Monday 17th June 2024

This letter is a Planning Objection for Planning Application 2024/70/90991/E (Yorkshire Country Properties)

Detail
**ROAD AND SEWER LONG-SECTIONS
ROADS 4 - 6**

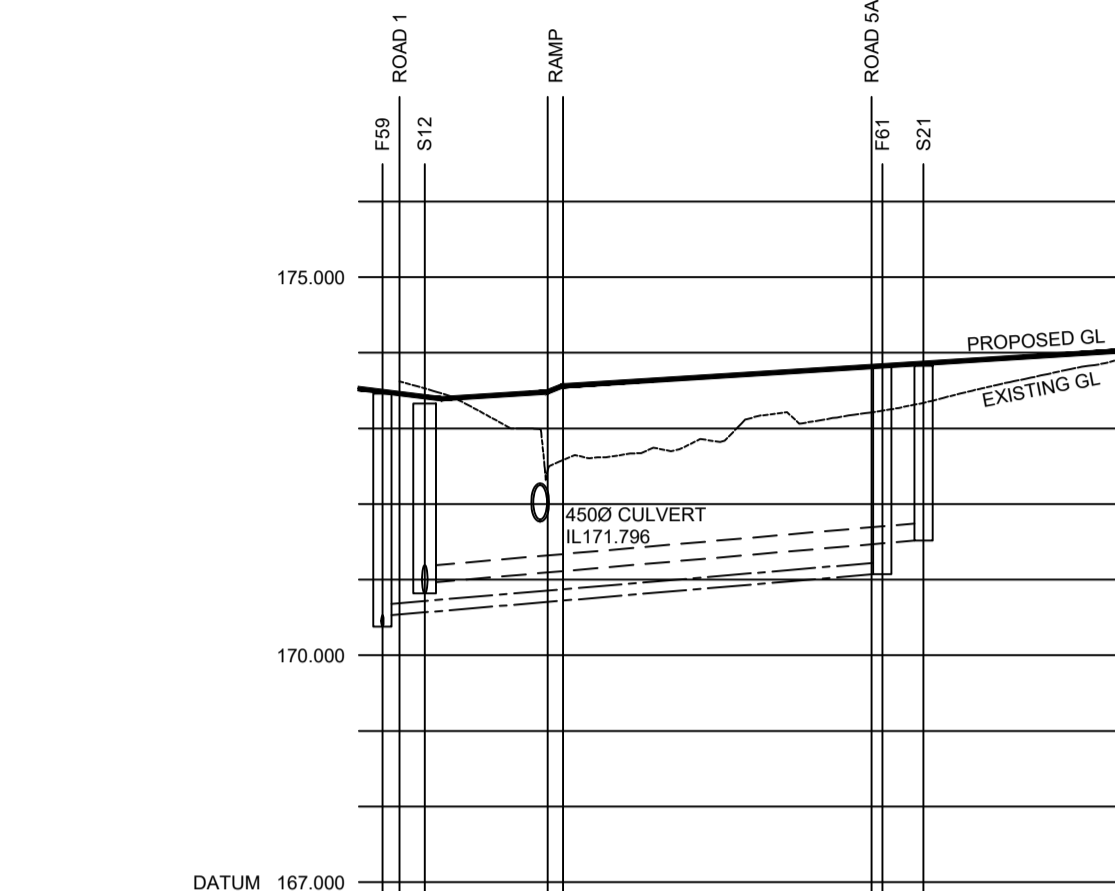
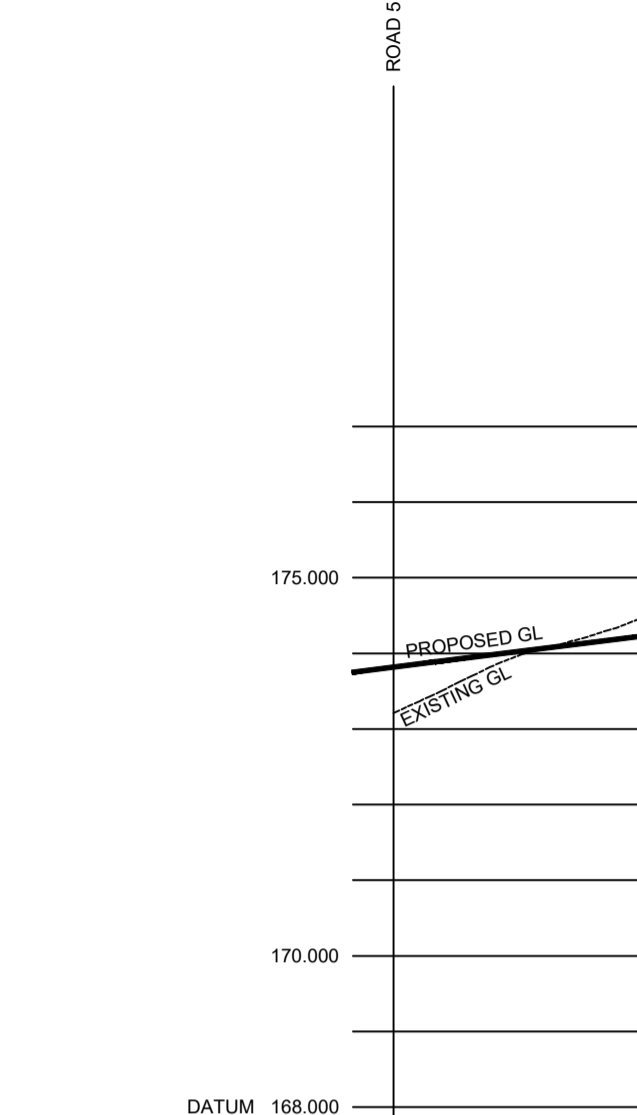
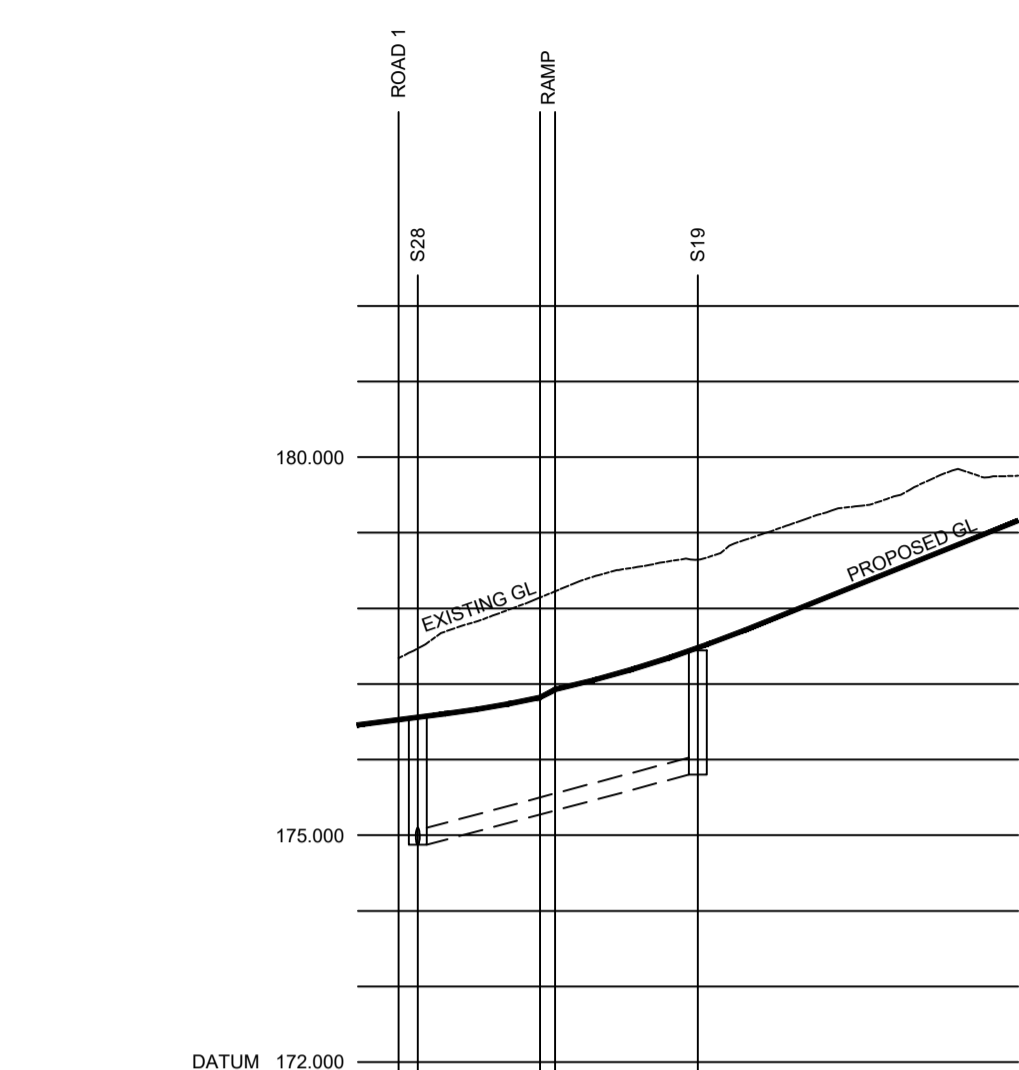
I wrote to Kirklees Lead Flood Management 3 months ago (copy attached) highlighting that the culverts installed are too small restricting the water flow and causing flooding but more important they have removed the protective cages!

Here we see a suggestion of the culvert capacity being increased from 450mm to 600mm with cages being installed to protect children.

The current plans show that this suggestion has now been abandoned!.

39 The solution would be simple at this early stage of construction by increasing the water capacity and
40 installing protective cages – the alternative is very serious !

I look forward to seeing revised plans showing increased capacity and cages.
